Planning application 2026/91314 - Further Neighbour Response to new information: 18 Aug 2026

We welcome the additional clarifying information, both plans and supporting information, recently provided by the applicant in documents posted to the Kirklees Council planning website on 14 August 2026, ie after the revised Public Consultation End Date of 3 August 2026.

title:
 Proposed Driveway Strategy

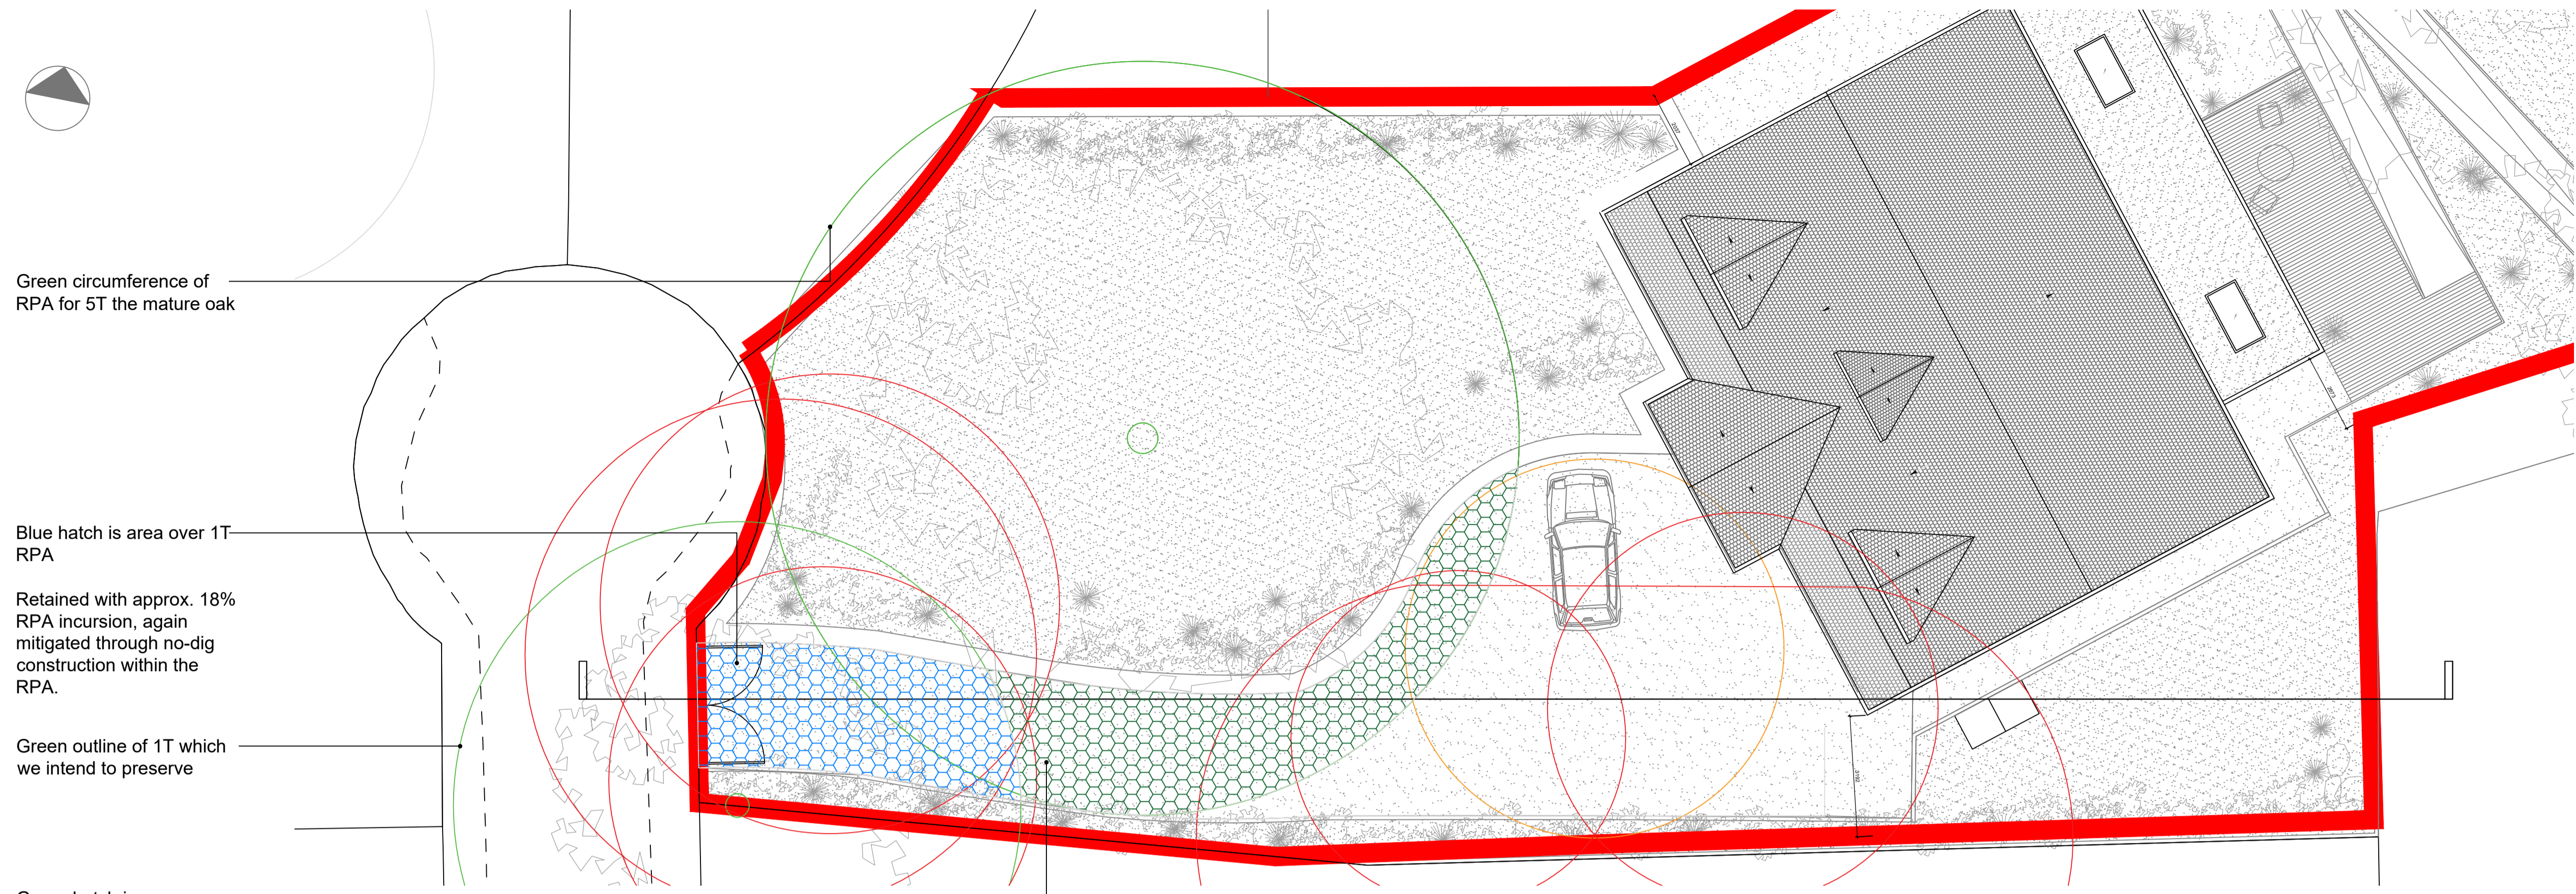
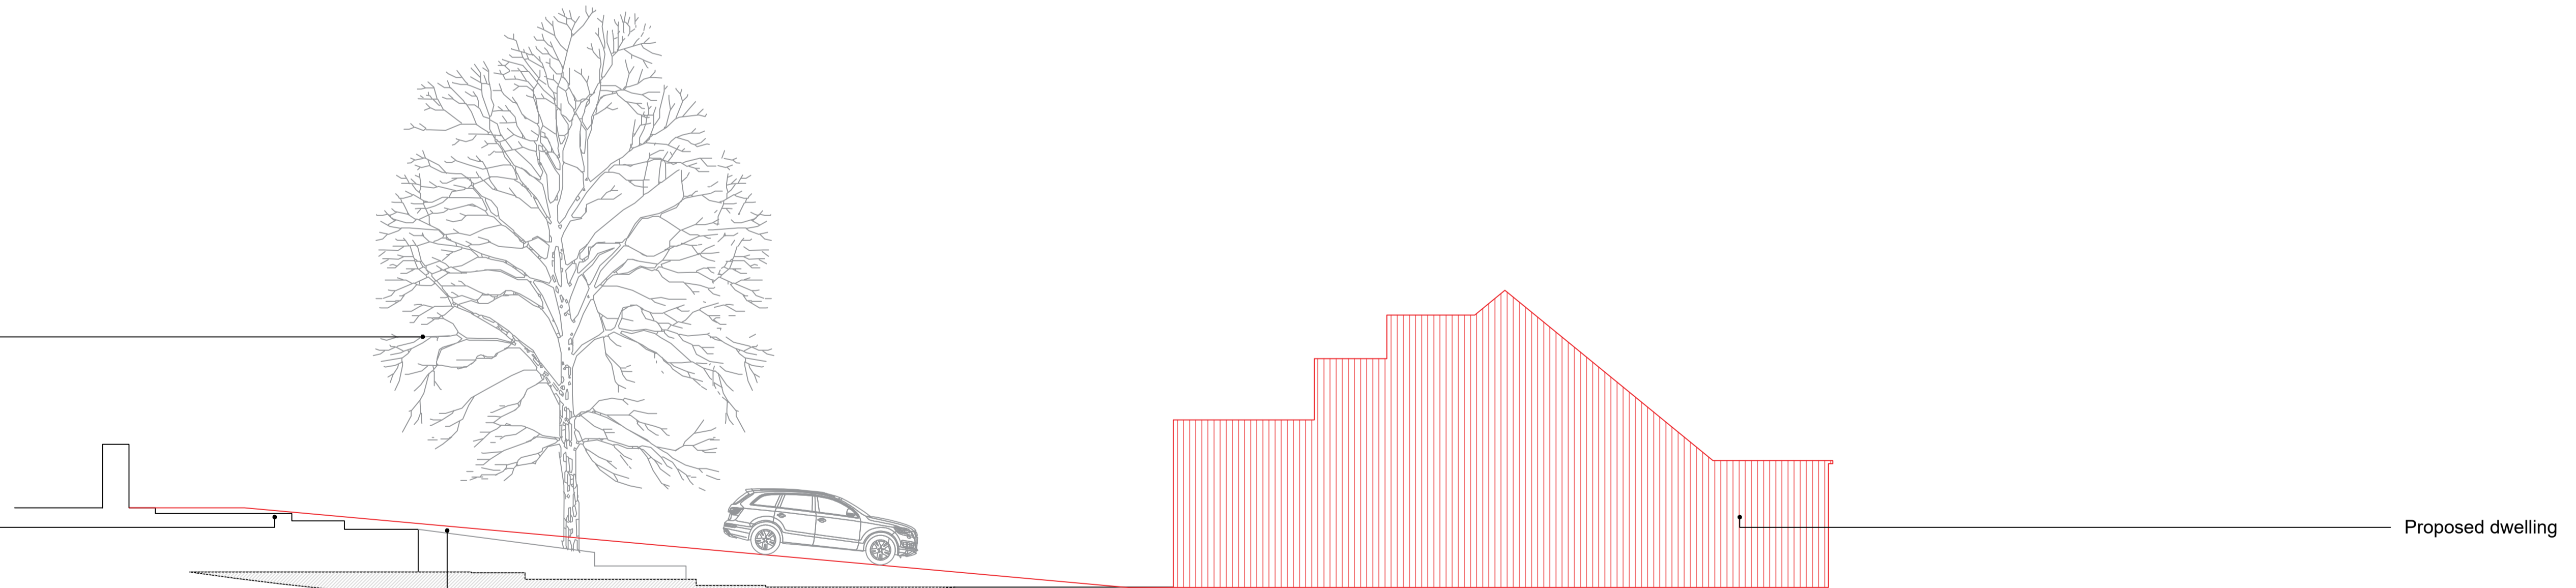
- Whilst a vertical cross-section is shown along the full length of the proposed drive (Plan 1153532), there are no cross-sections perpendicular to the drive to show the changes of level from the proposed excavated drive to the boundary with 2 East Avenue, and no explanation of the nature of materials to be used, or the construction methods, for new retaining walls/slopes/banking.

- We note in the 31 July Arboricultural Method Statement that there is no 'protective fencing' proposed around the Root Protection Area (RPA) of either tree 1T (at the entry to the drive) or tree 22T (very close to the SE corner of the proposed house). (plan 1153528)

- We note that the accompanying plan showing the RPA of tree 1T covers approximately 90% of the width of the proposed new drive at its entrance and that the RPA (based on a possible current under-estimate) of the offsite tree 22T may abut the completed foundations at the SE corner of the proposed new house.

We ask that amended plans be produced to include 'protective fencing' to include, as a minimum, the RPAs of trees 1T and 22T, and that this be fully maintained throughout the period of construction.

Proposed Site & Roof Plan
Scale 1:200

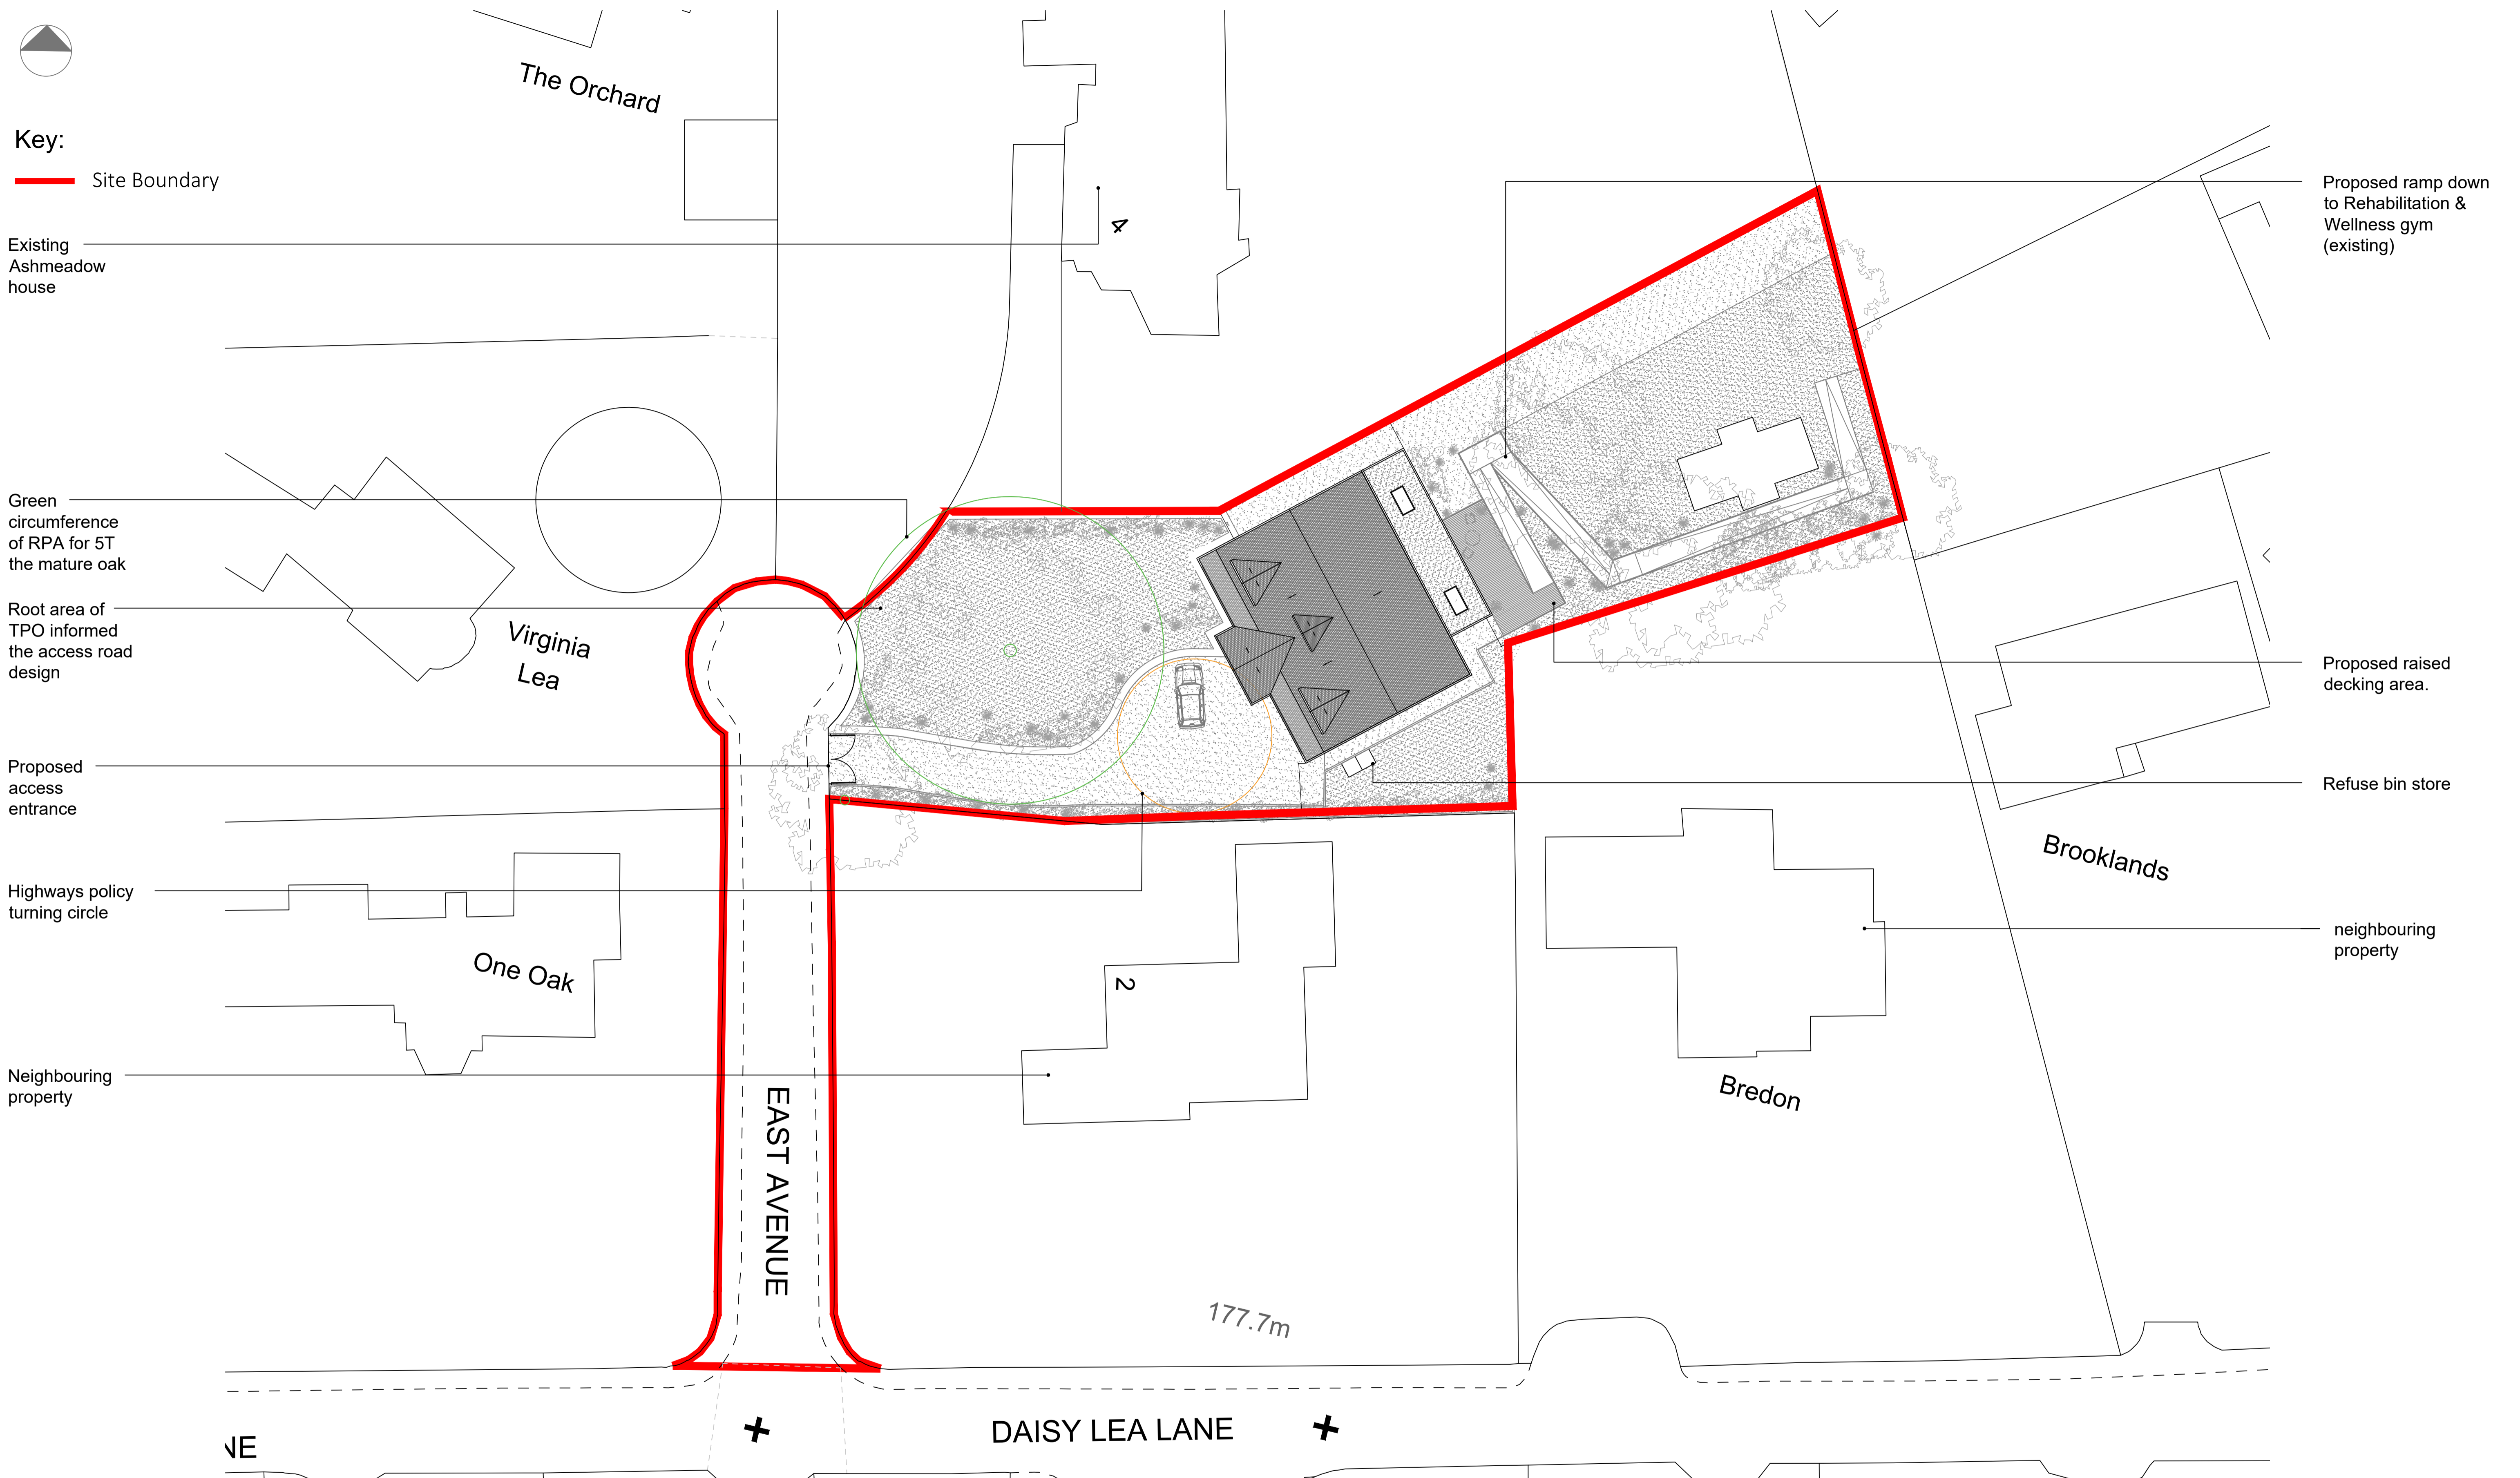
- In addition, the detailed plans suggest that the SE corner of the proposed new house is underneath the existing canopy of this mature oak tree (22T), whose trunk is only approximately 6m distant.

We restate our request that all lighting in the vehicle turning area be pointed downwards and not towards 2 East Avenue.
